**Office of
Environment
& Heritage**

Our Ref: DOC16/527443
Your Ref: MP 06_0316 MOD 5

Re: Response to Submissions - Modification application to Project Approval - Cobaki Lakes Residential Community Development (MP 08_0200 MOD 5)

APPENDIX B – EARTHWORKS FENCING PLAN

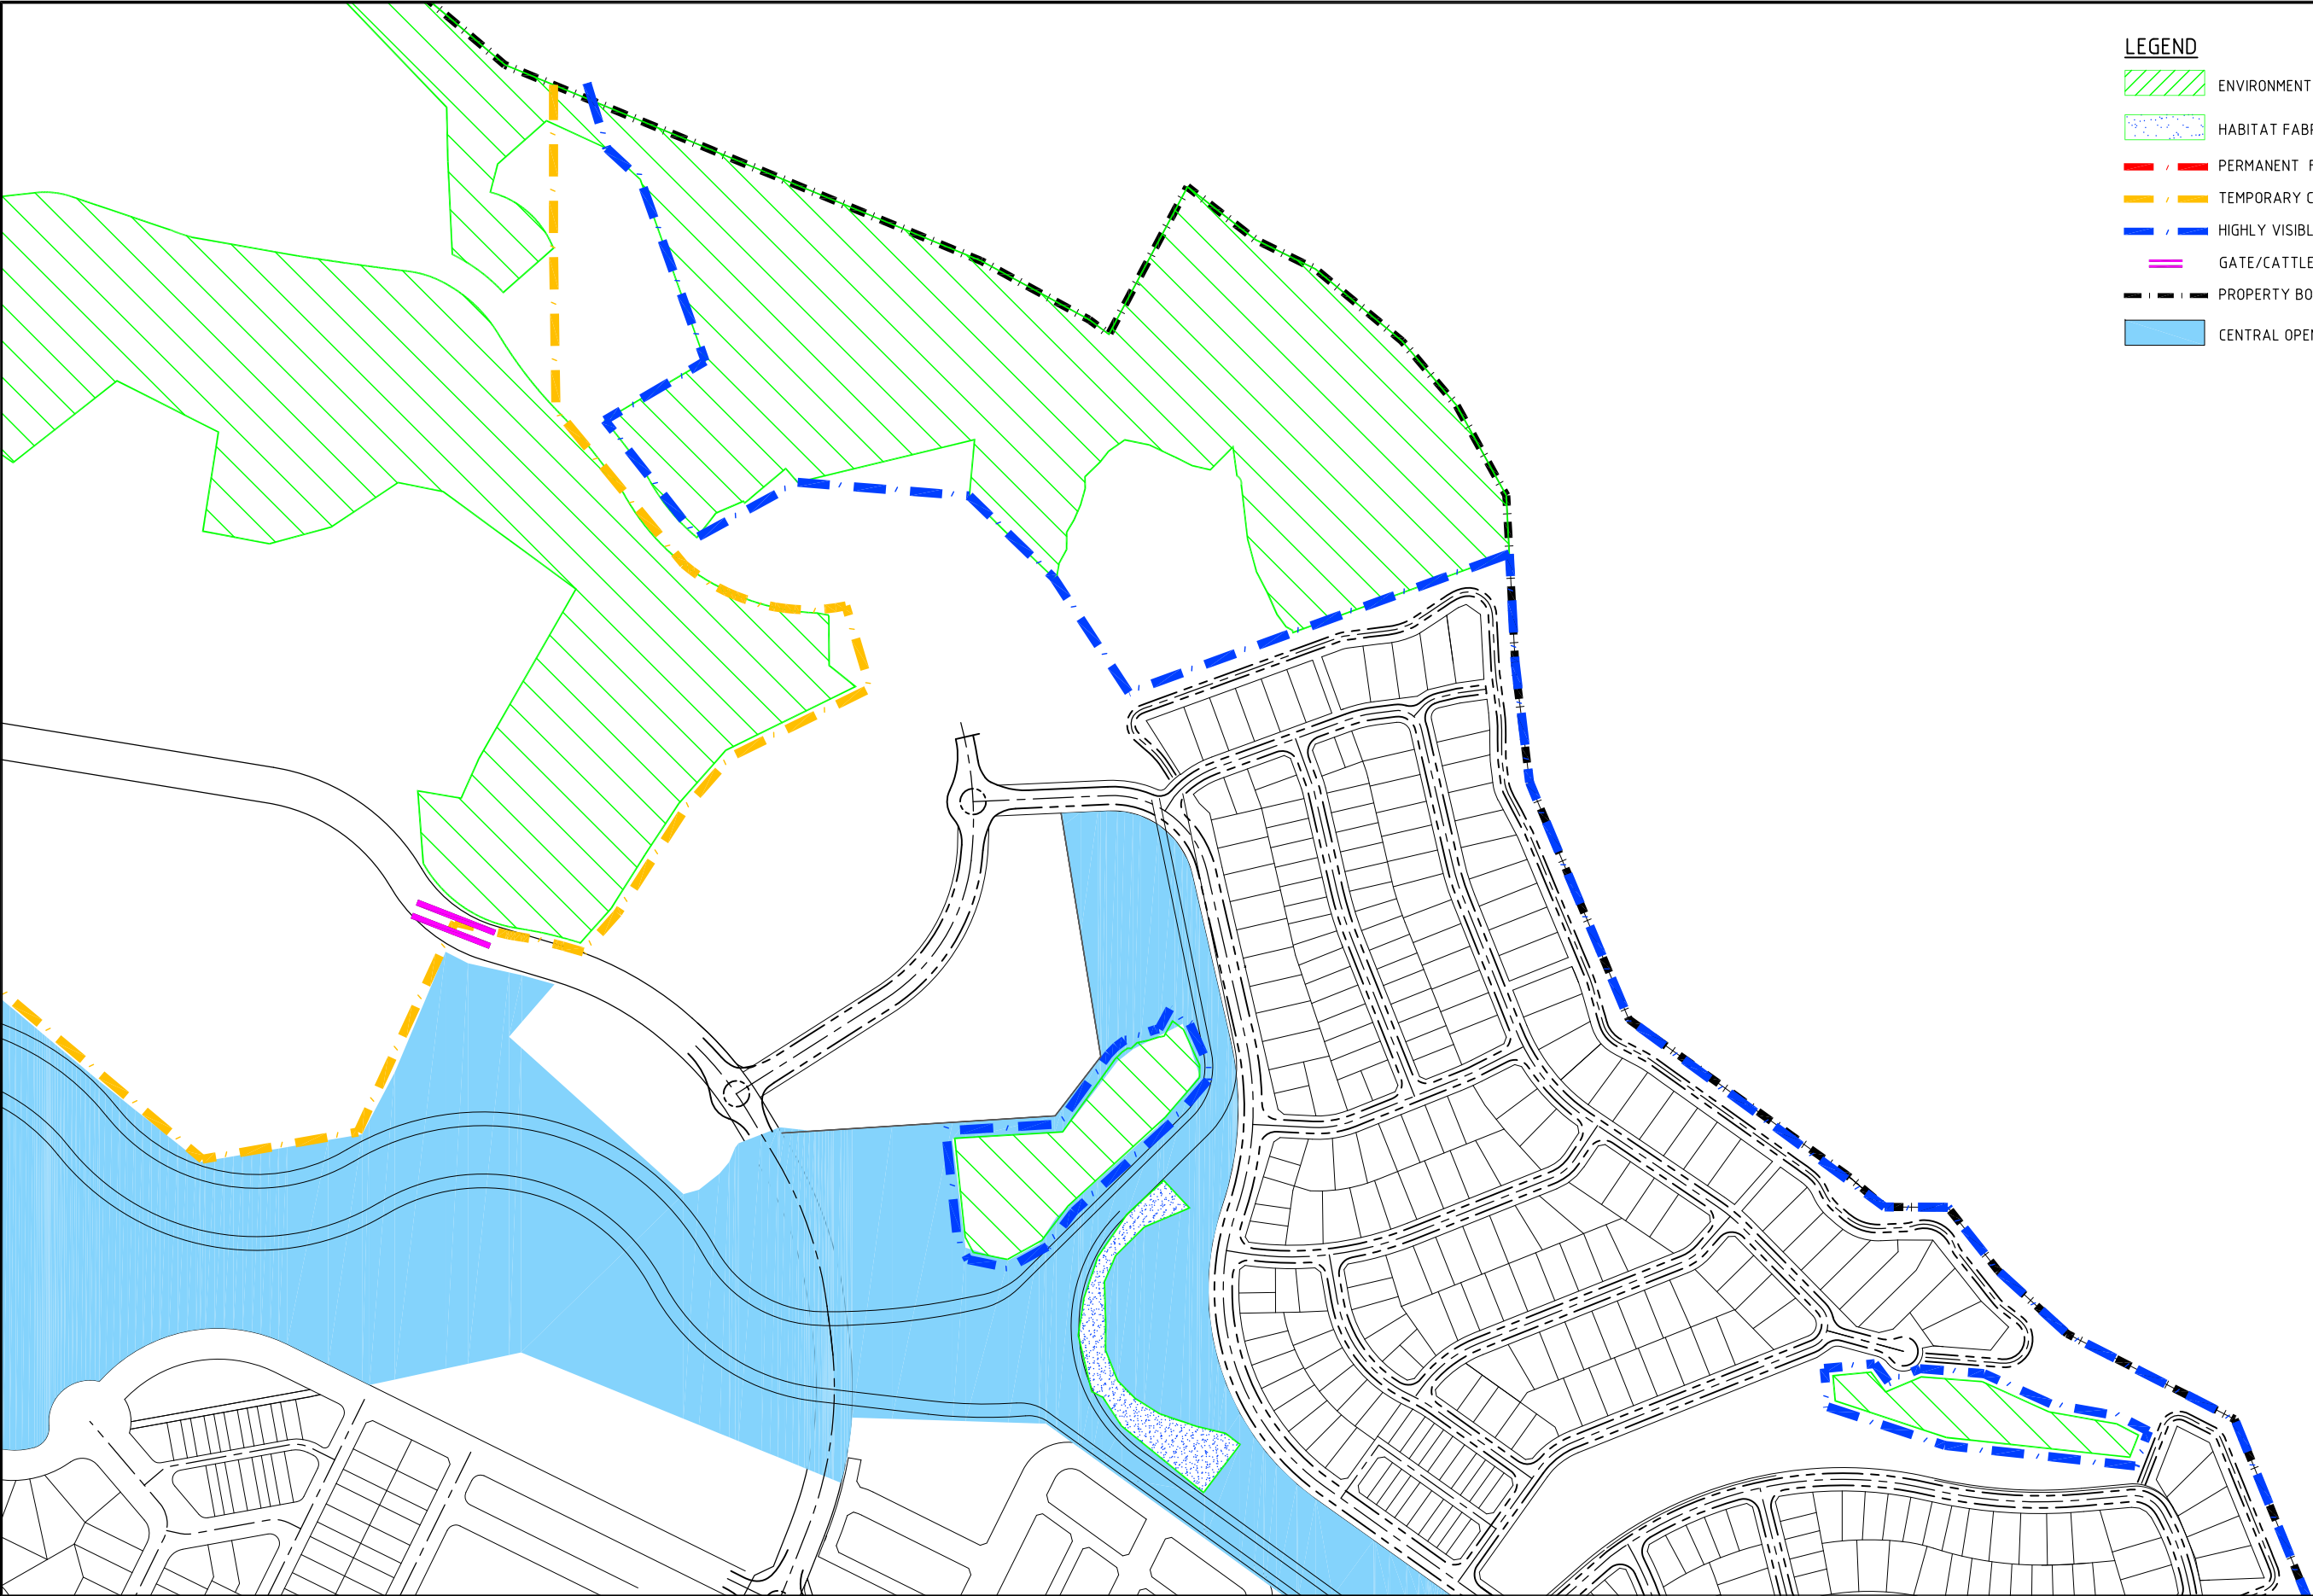
OEH provided a submission on the proposed modification on 1 November 2016. In that submission OEH outlined some key principles regarding fencing in relation to areas proposed for protection and/or rehabilitation should be fenced regardless of their condition state. OEH took this to include permanent and temporary fencing.

On that basis, OEH does not support any proposal to reduce or delay fencing associated with areas proposed for protection and/or rehabilitation.
